Town & Country Planning Act 1990 (as amended)
Town & country Planning (Development Management Procedure) (England) Order 2015
Application for Planning Permission for Works or Extension to a Dwelling

Development Single storey and two storey extensions, creation of additional habitable roofspace, and alterations including external rendering and cladding

Location Little Glebe Little Heath Road Fontwell Arundel

Proposed Extension and Alterations
at Little Glebe, Little Heath Road, Fontwell
for Mr and Mrs R Lynes
Drawing P02 September 2018 Scale 1:100 @ A2
Planning Drawing - First Floor Plan & South Elevation

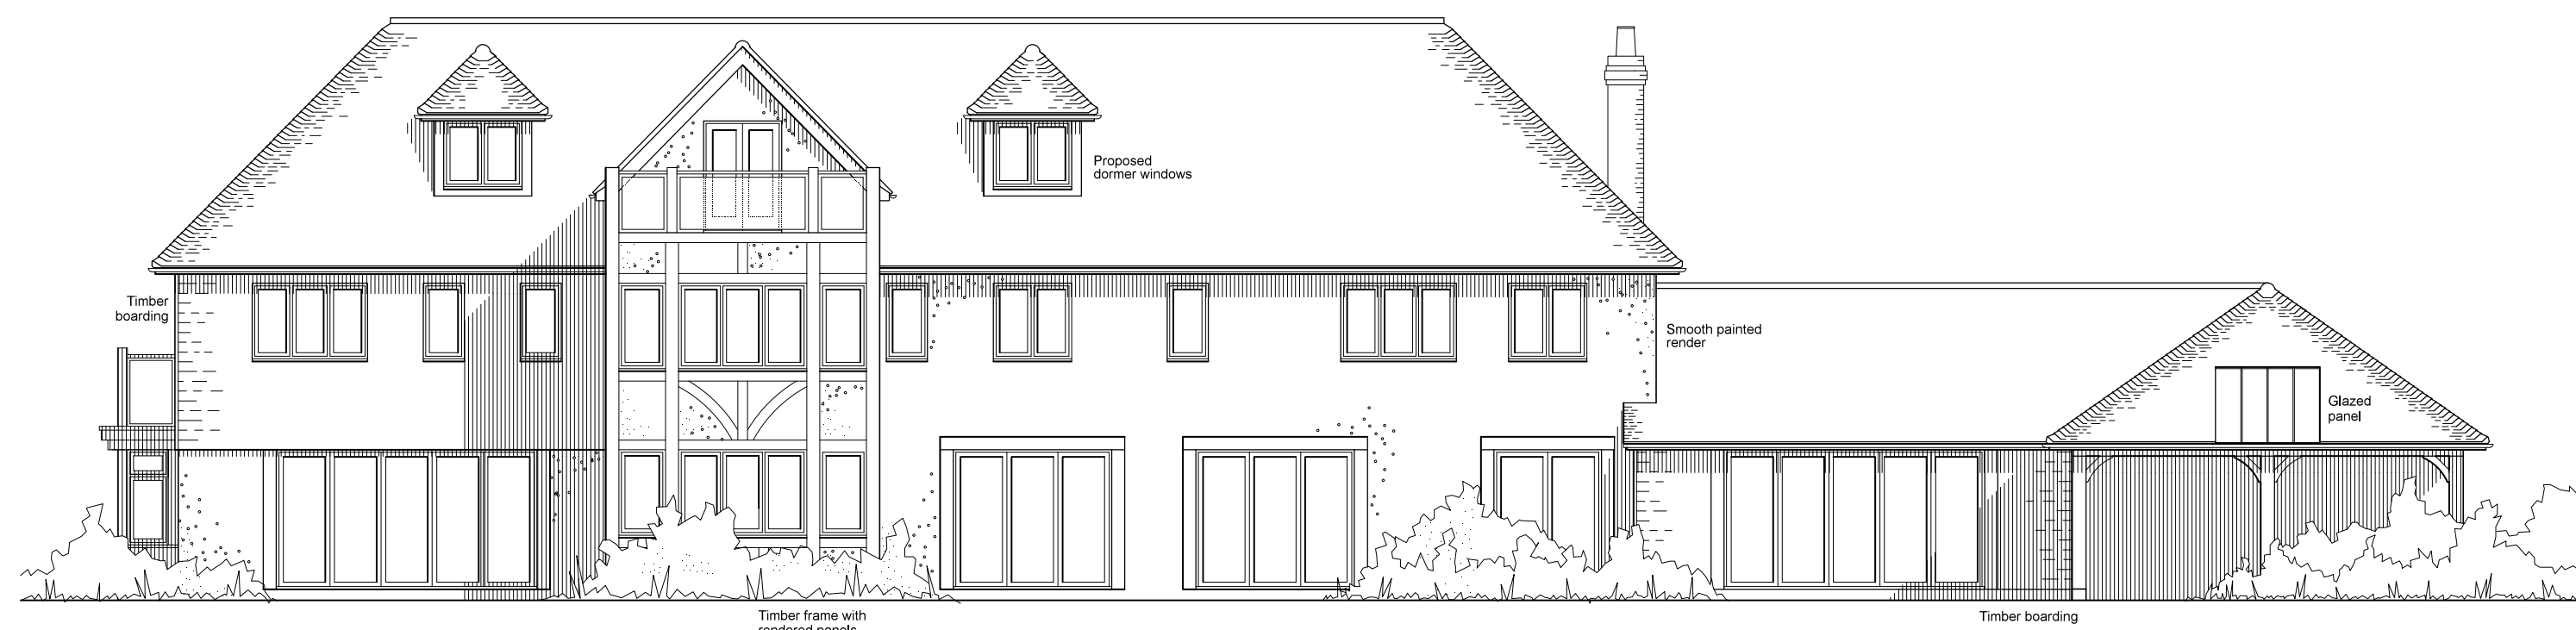
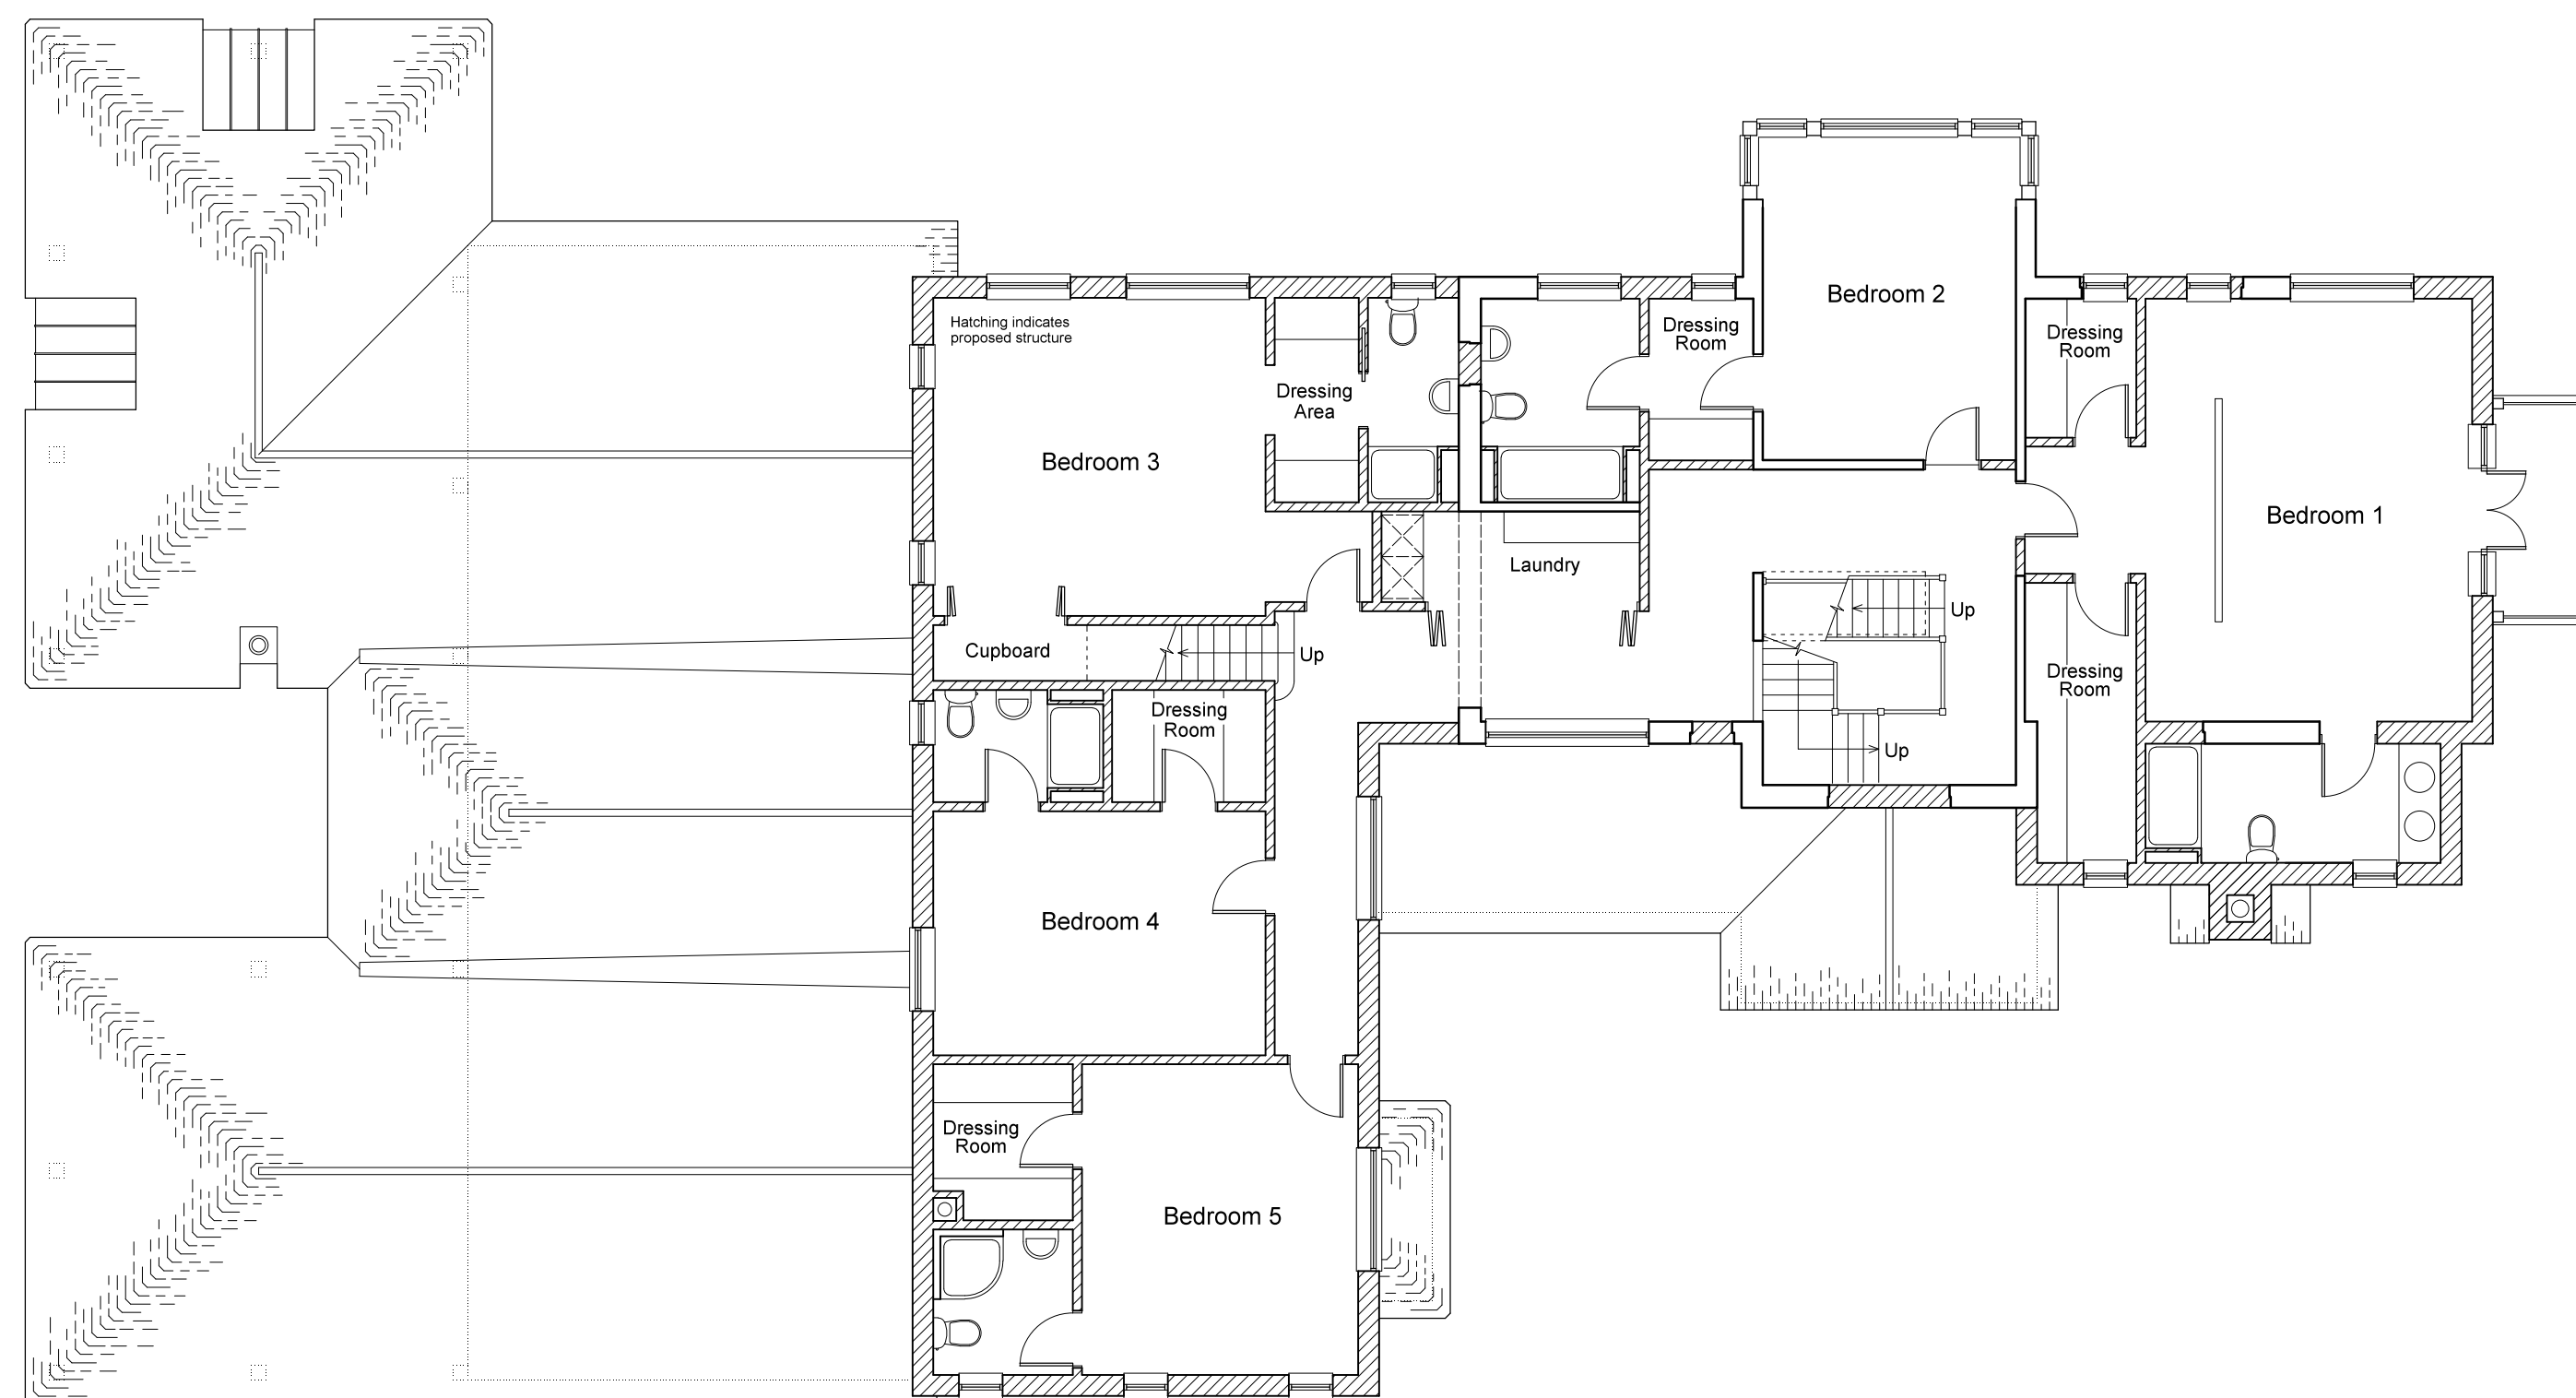
The roof does not match between the proposed roof plan and the second floor plan and the proposed north, south and west elevations.

Proposed Extension and Alterations
at Little Glebe, Little Heath Road, Fontwell
for Mr and Mrs R Lynes
Drawing P03a September 2018 Scale 1:100 @ A2
Planning Drawing - Second Floor Plan & E & W Elevations

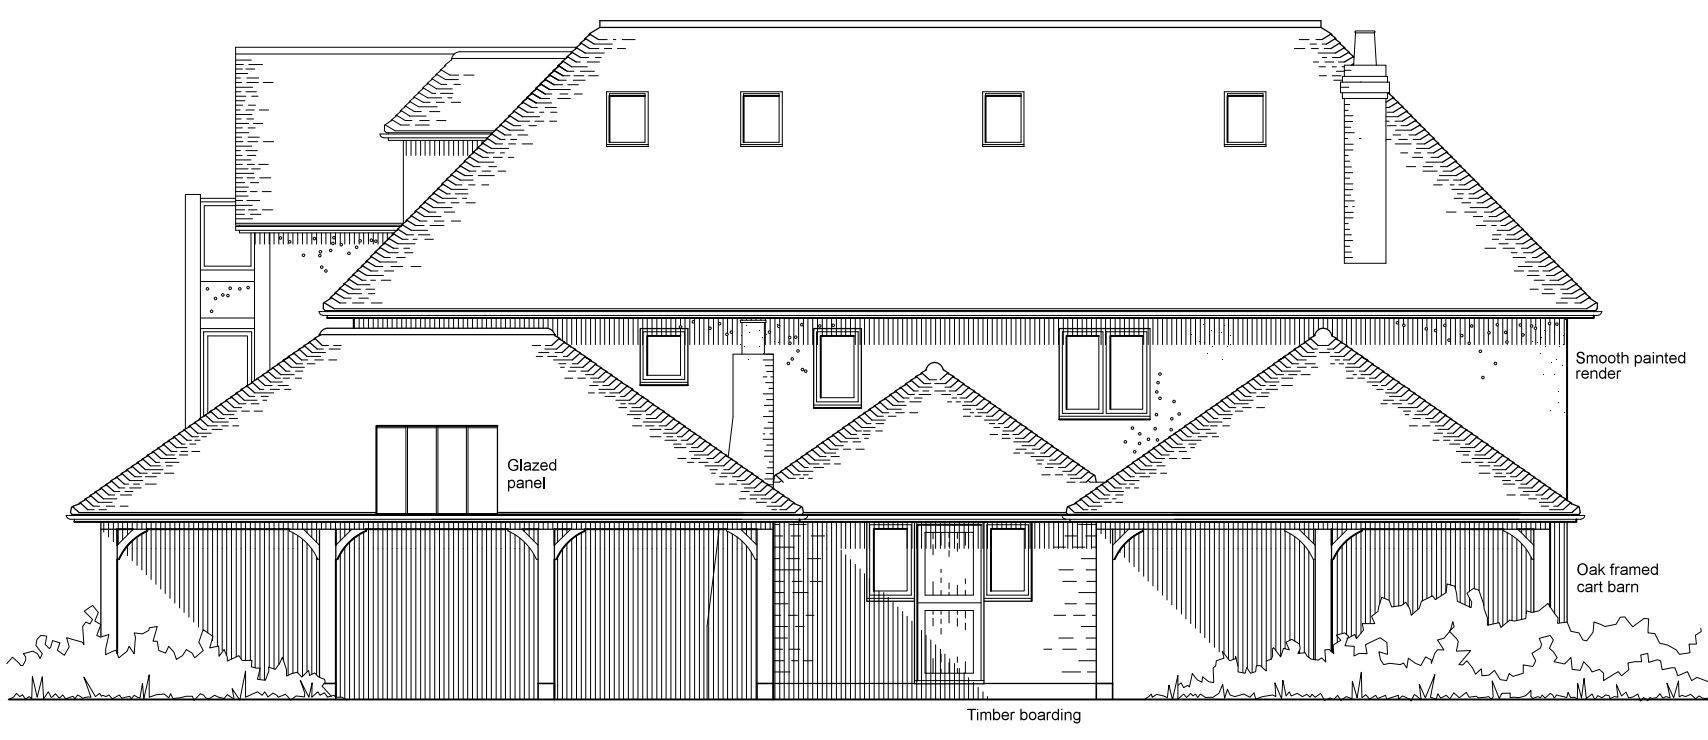
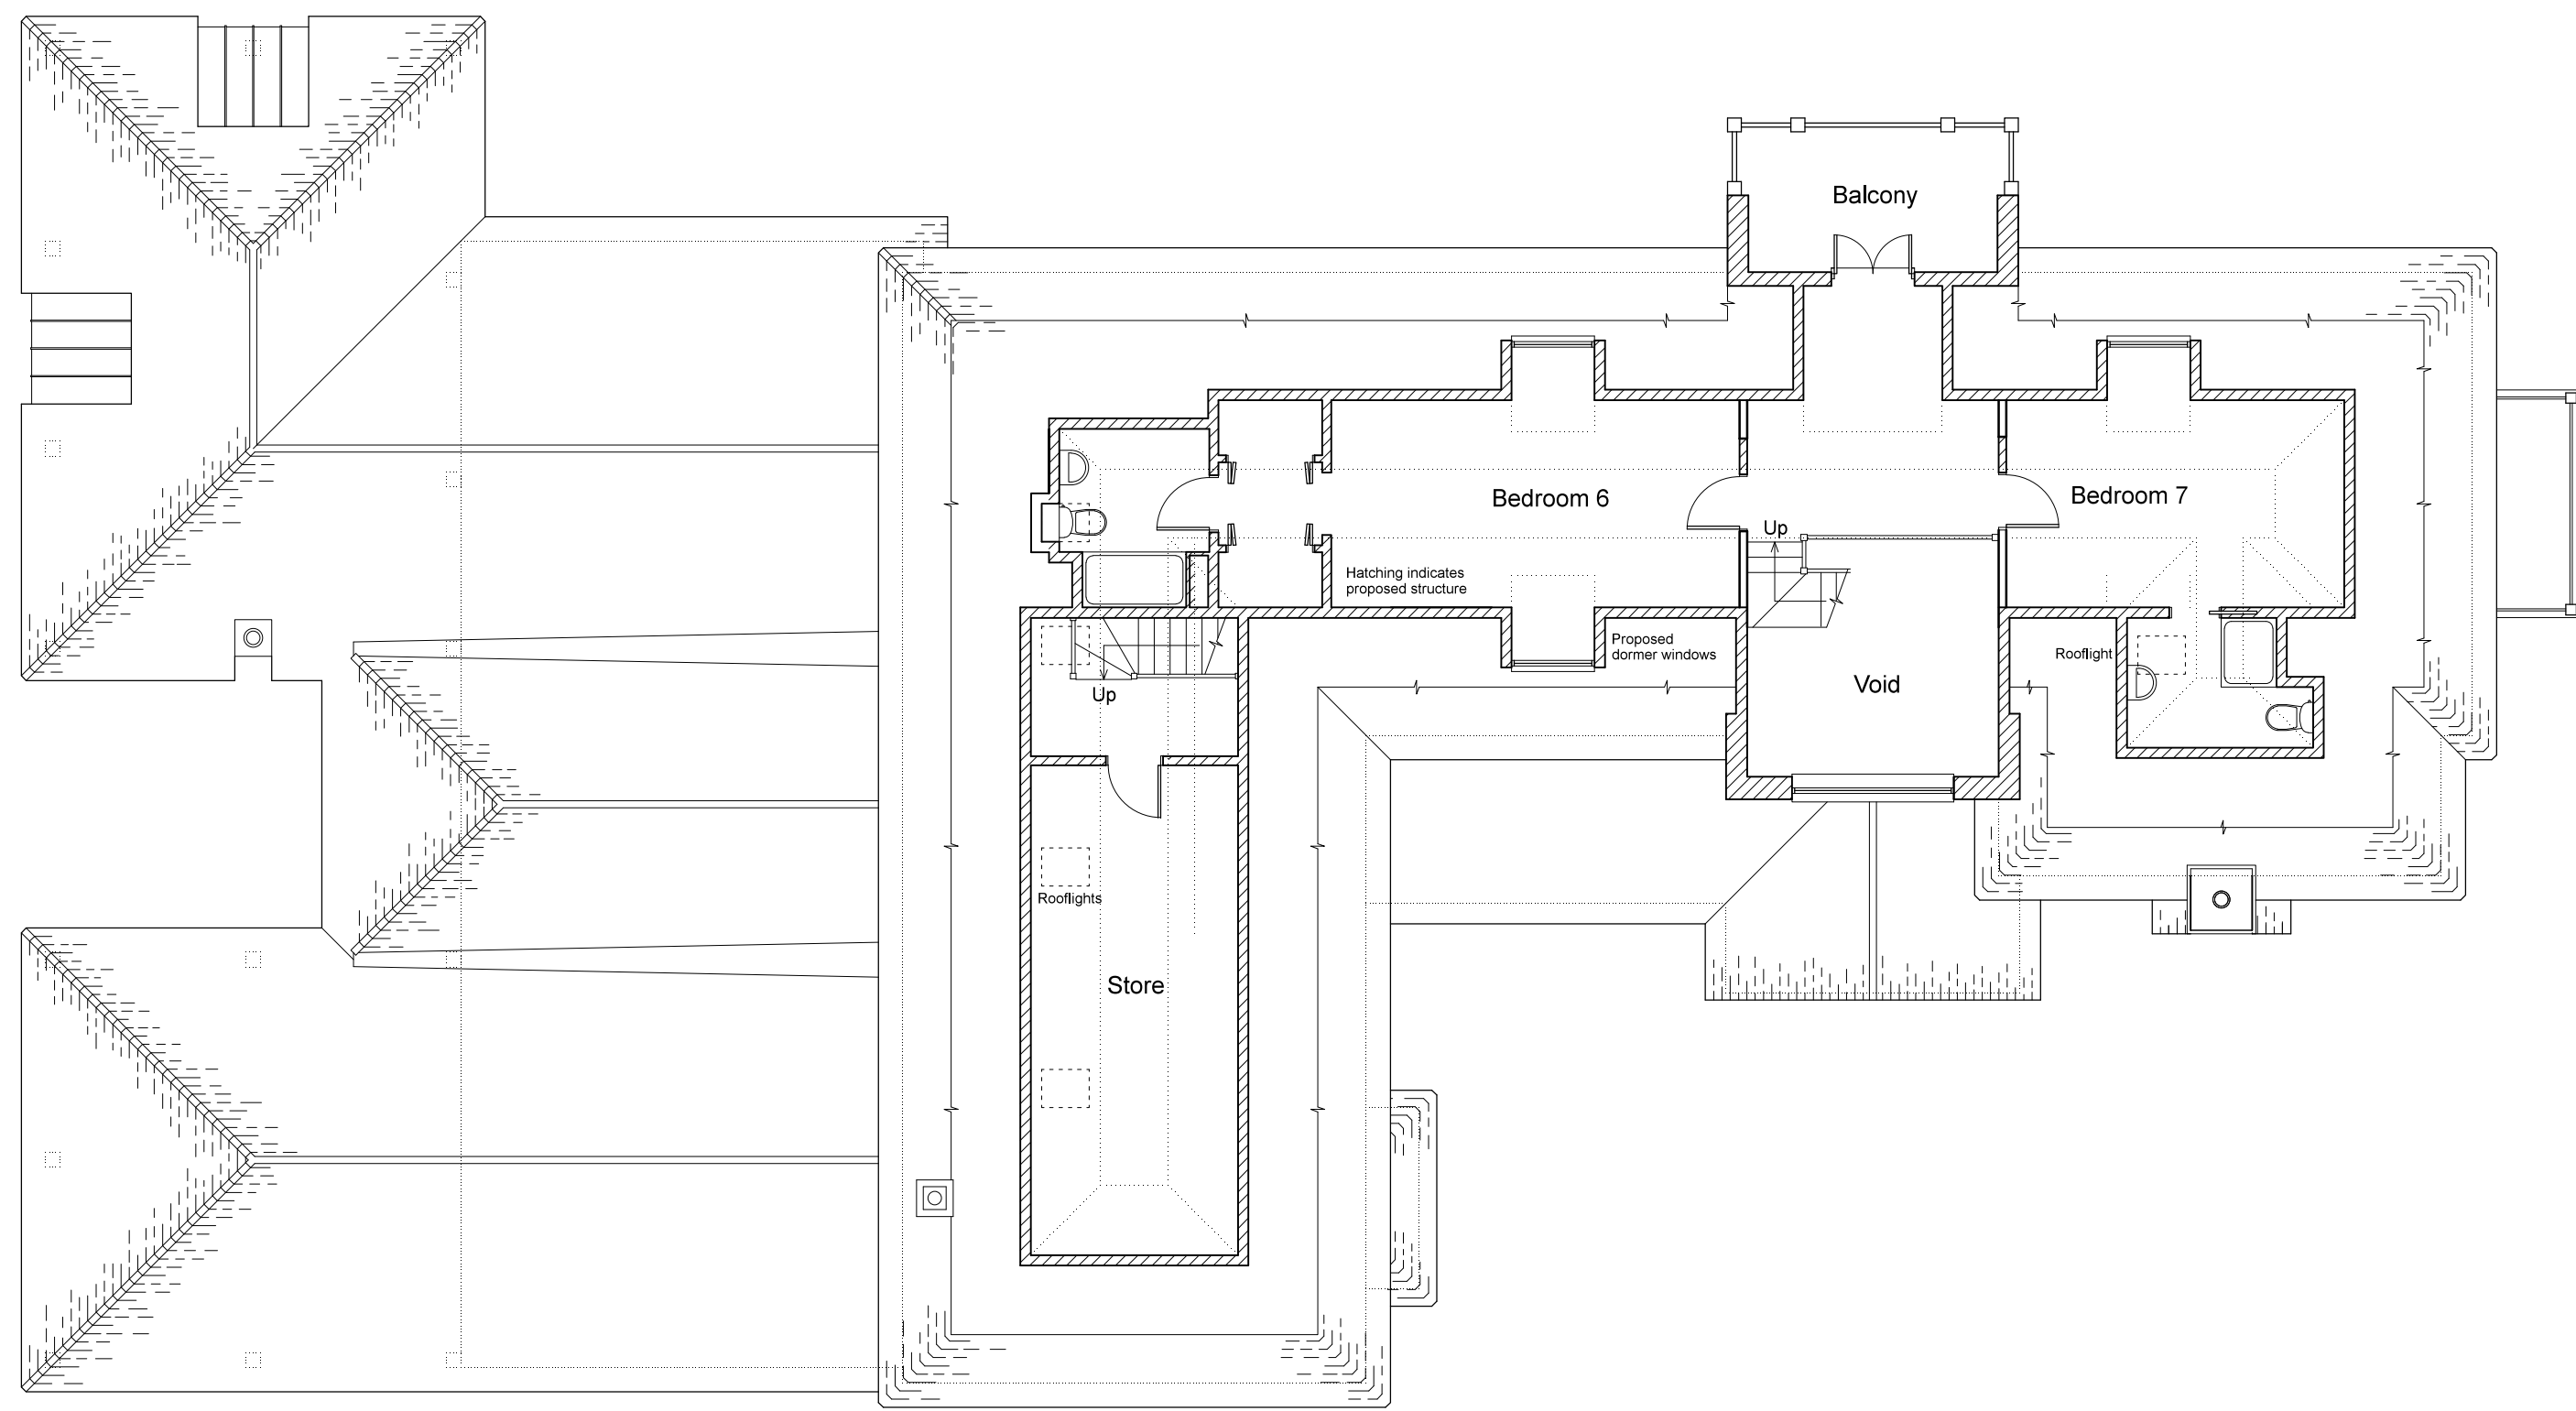
The windows do not match between the proposed ground floor plan and west elevation.
